CONSULTEE RESPONSE (Council's arboriculturist)

Reference: AW/84/22/PL

Proposal: Variation of condition imposed under AW/28/19/PL relating to condition 2-plans condition (updated plans and Arboricultural Impact Assessment and Method Statement.

Location: Land to the North of 276 Aldwick Road, Bognor Regis, PO21 3QH

Drawing Title
Location of Section Lines

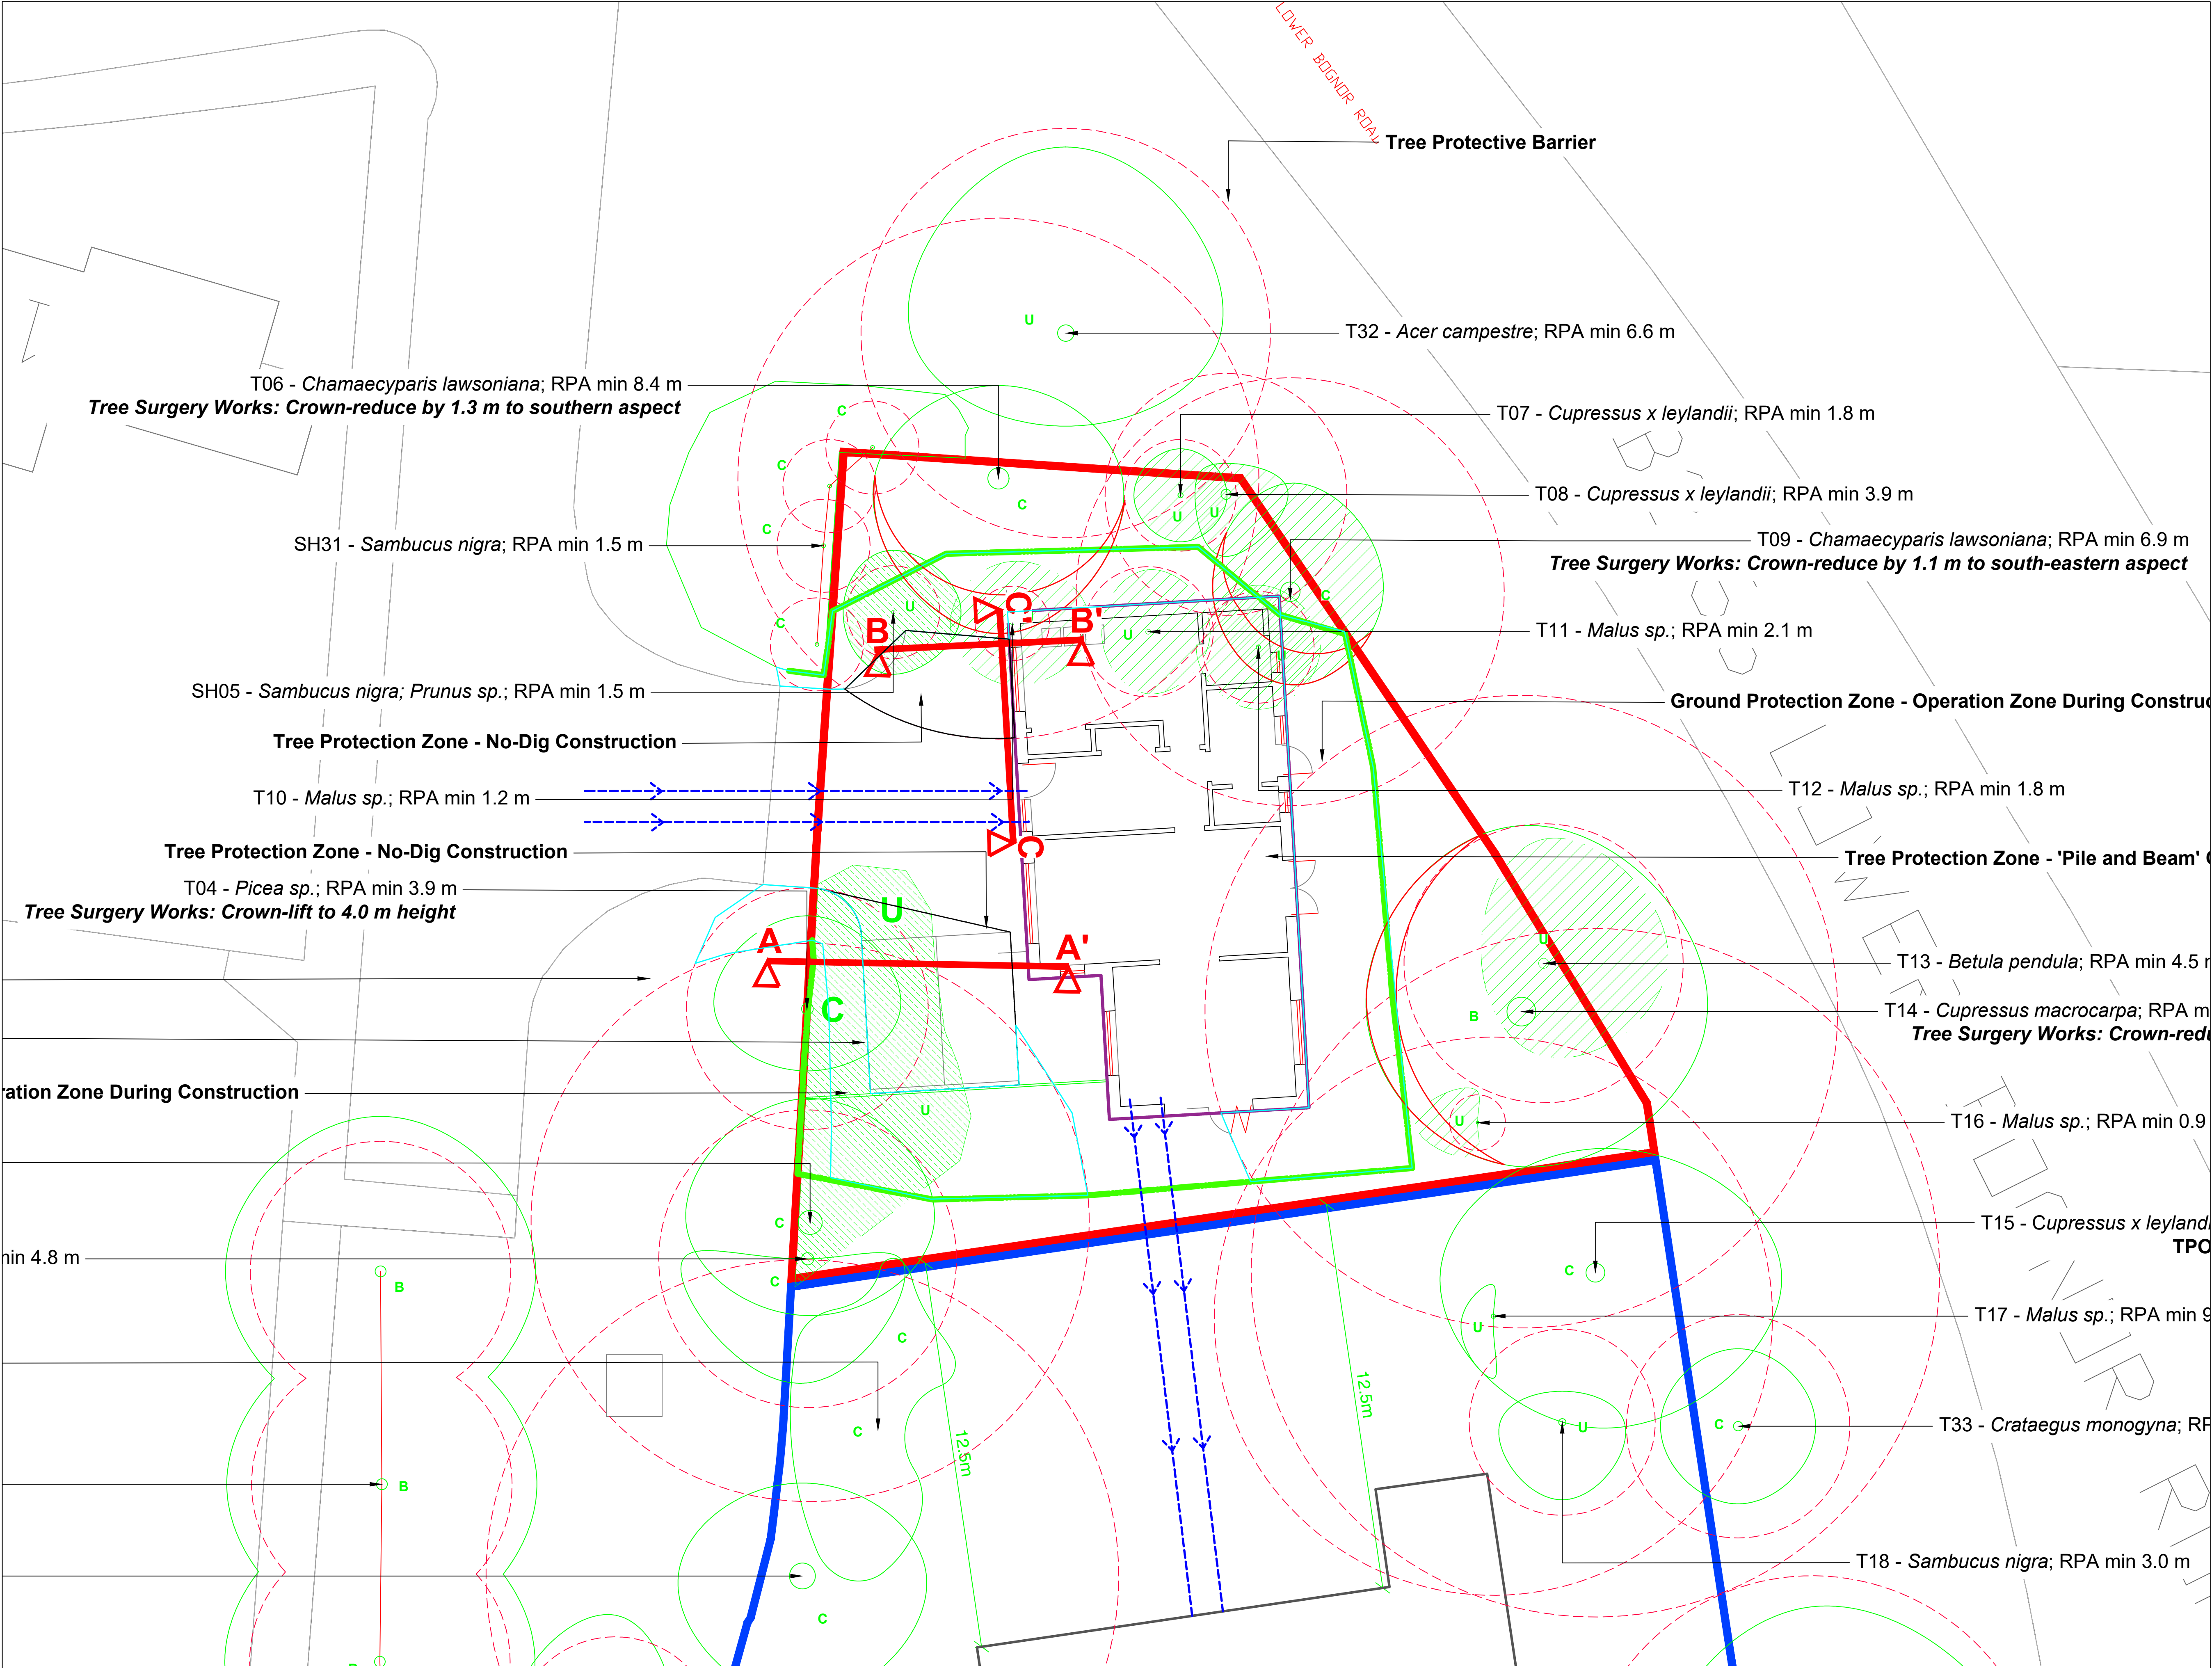
Based solely on comparison of the above plans no additional tree removal or tree surgery is proposed, which is misleading. Additional tree removal has been illustrated on Location of Section Lines, dwg. no. LLD2330-ARB-DWG-003, Rev 00, 05.05.21, namely the removal of T8 & T9. Furthermore, this tree removal (additional two trees) has been described in the AIAMS and Tree Schedule so I make recommendations on that basis.

T08 had been identified as unsuitable for retention so its removal now cannot reasonably be argued against.

T09 could not realistically be retained as part of the latest proposal due to proximity to dwelling. Its removal will extend the gap in the east boundary treeline when viewed from the public highway.

If the application is to be approved, a **revised Tree Retention and Protection Plan** (see below) should be sought, to ensure the proposal is adequately illustrated for the benefit of all interested parties and importantly for those contractors employed at site.
